From: Anita Gardner <Anita.Gardner@arun.gov.uk>
Sent: 03 July 2020 09:38
To: Planning.Responses <Planning.Responses@arun.gov.uk>
Subject: FW: F/10/20/DOC - South Yard B Wicks Farm

From: Sarah Burrow <Sarah.Burrow@arun.gov.uk>

Subject: RE: F/10/20/DOC - South Yard B Wicks Farm

Cellular Soakaway
Dims: 10m x 10m x 0.36m deep
Required Attenuation Volume: 32.9m³
GL: 6.10mAOD
CL: 4.69mAOD
IL: 4.33mAOD (1.77mbgl)

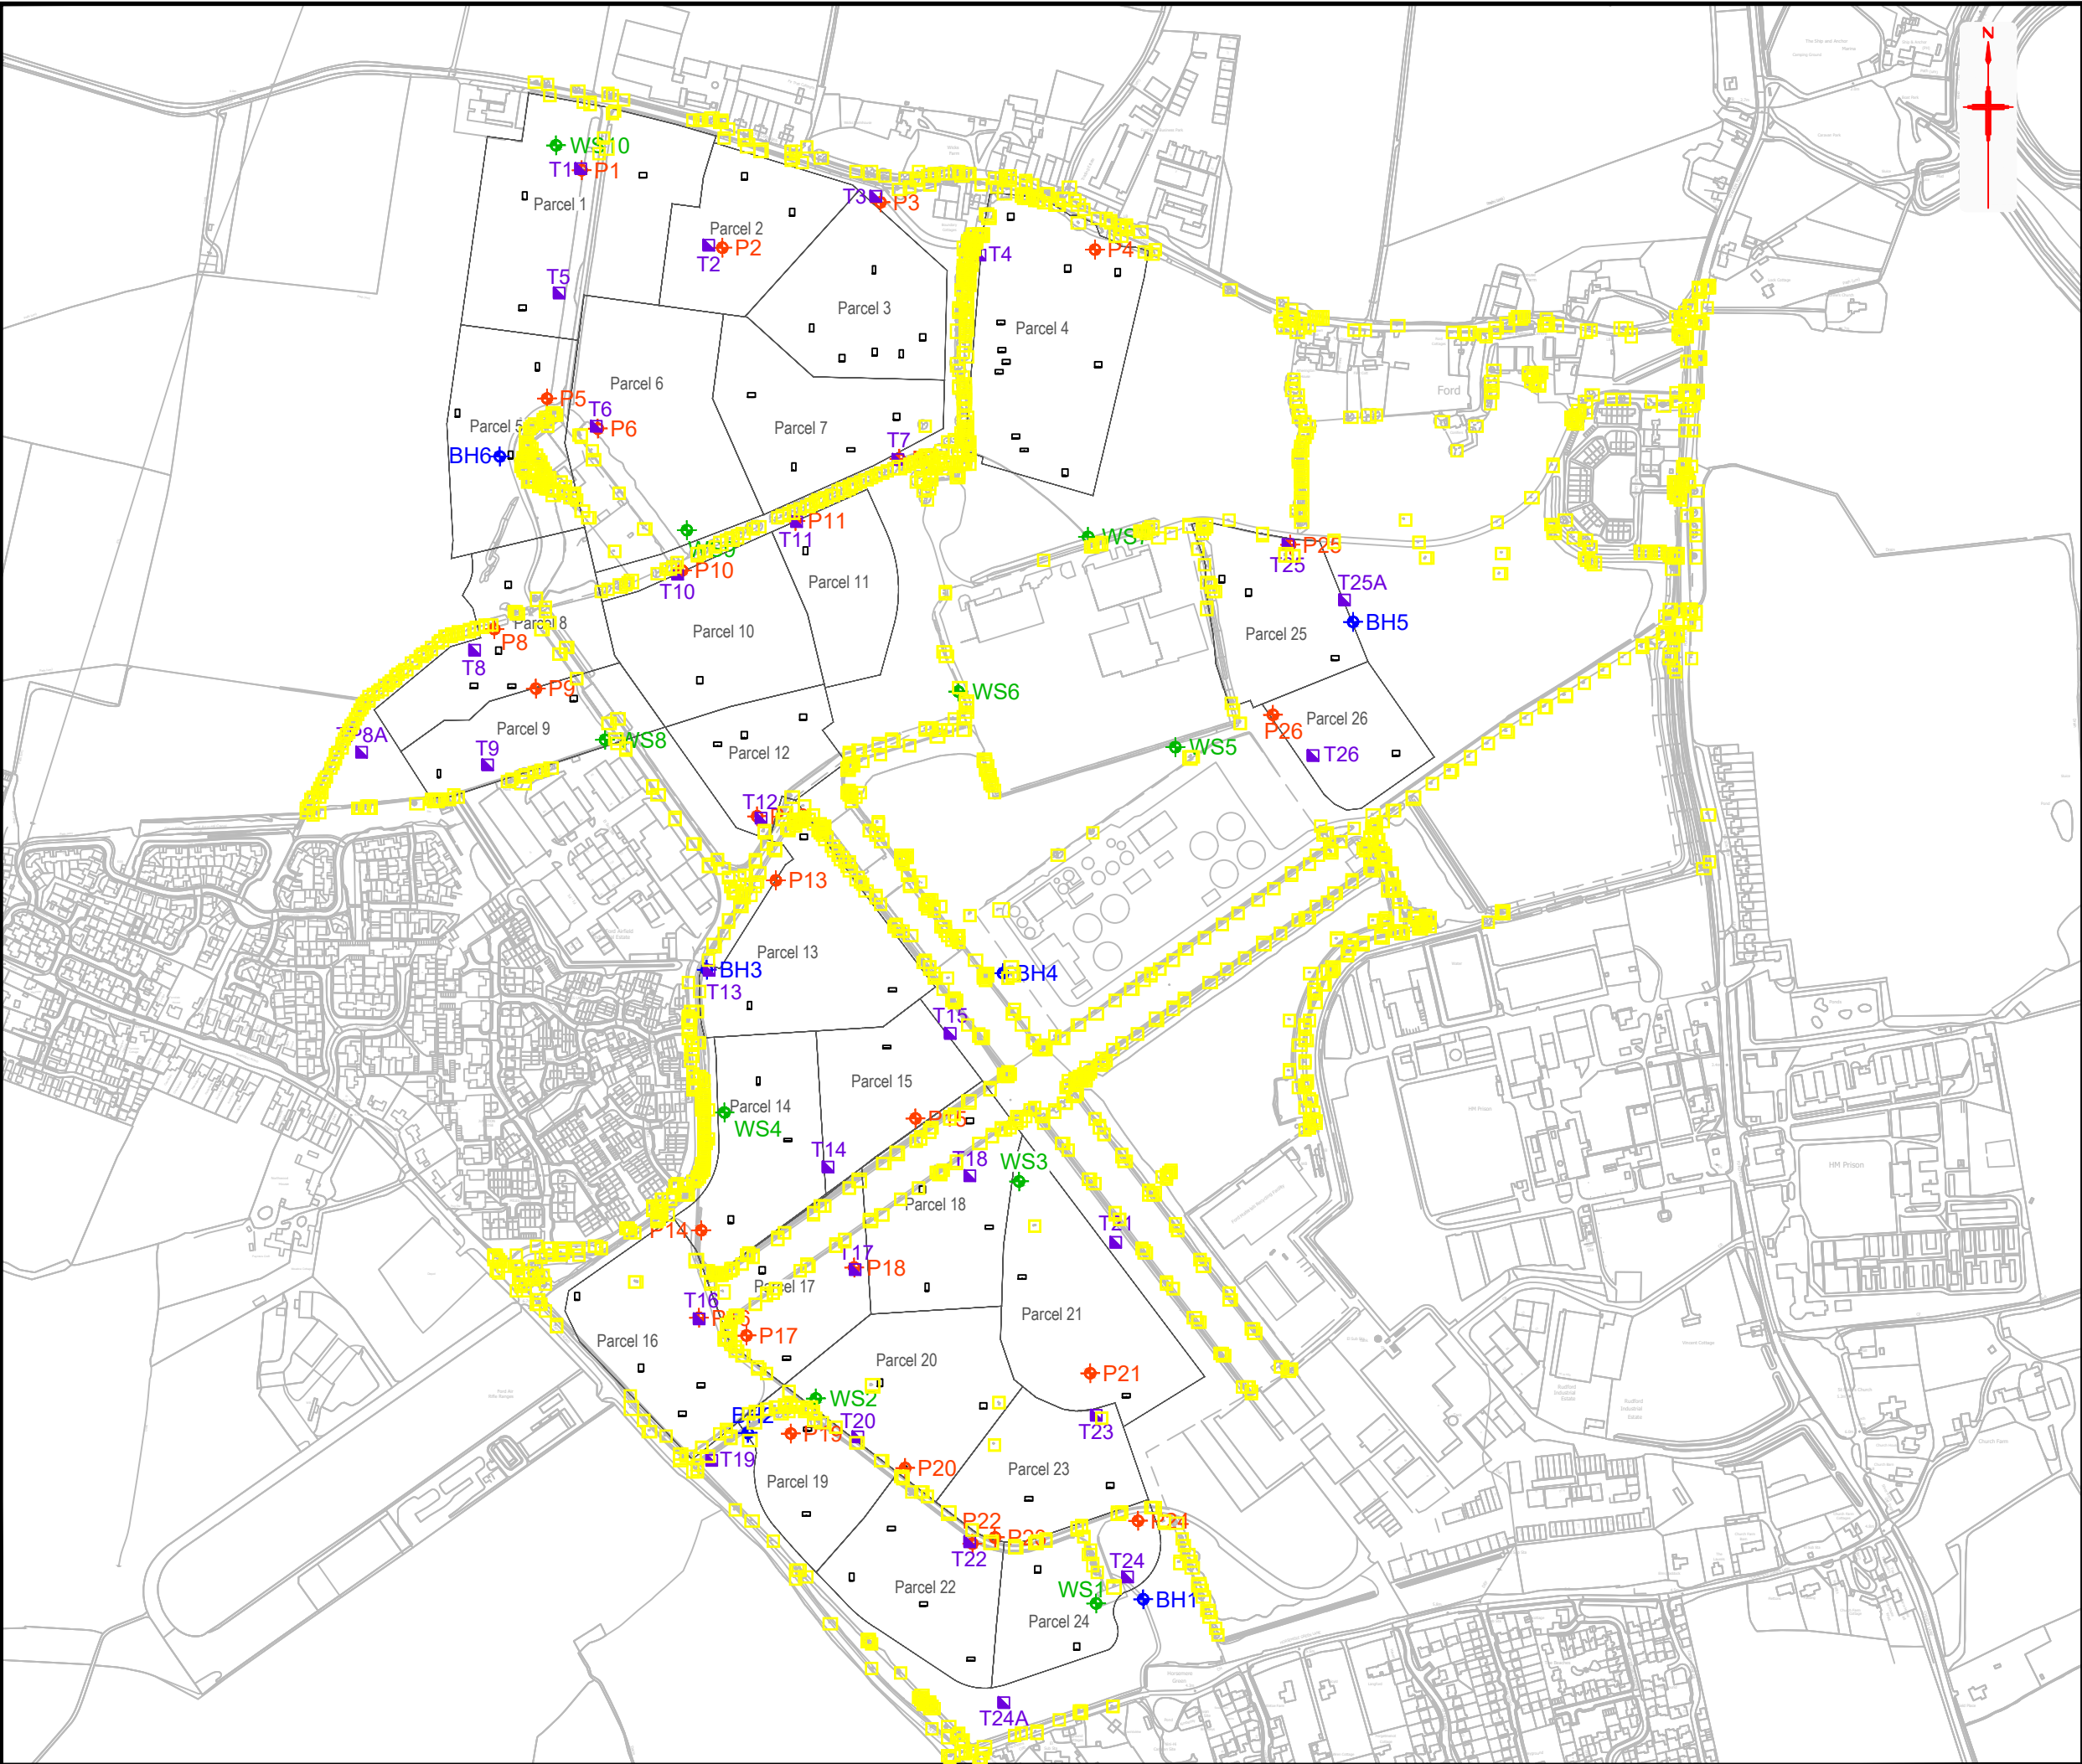
1: As the soakaway acts as a blanket with an effective depth of 0.3m it is appropriate to use the base for the calculations. However, the soakaway invert level is at 0.8mbgl, this depth does not correspond with the infiltration test depth of 1.77mbgl. If the infiltration test results are to be used then the soakaway base should be at the same depth as the testing (noted that this was at the top of the chalk stratum with clay above). There are two options:

- a) Make the soakaway deeper to correspond with the existing tests. The deeper soakaway may have to utilise the sides only for the calculations, please contact us to agree this in advance of a further submission. This has technically been done, however, considering that other elements of the DOC need revision it is recommended that the design is revisited. At present the previous 'blanket' solution has been placed at a lower depth. It is questioned whether it may be more appropriate to redesign the soakaway dimensions to maximise the allowable side infiltration and reduce the volume of excavation.
- b) ~~Carry out winter infiltration tests at the depth of the proposed soakaway and use these to inform the design, utilising the base in the calculations.~~ Not applicable.

- a) Cover levels, types and invert levels for all inspection chambers and silt trap. Cover types not included. Even if just a description of types according to loading in the notes. It is also not clear that the final inspection chamber is a silt trap/catch pit. Please make this clear on the key and include a sump level.
- b) ~~Pipe diameters, pipe types and gradients/falls.~~ Done
- c) ~~The exact dimensions of the proposed soakaway, the crates to be used noted on this drawing.~~ Done

3: We expect to see construction detail drawings for all components including: Not provided

- a) Pipe bed and surround
- b) Inspection chambers and silt traps
- c) Soakaway
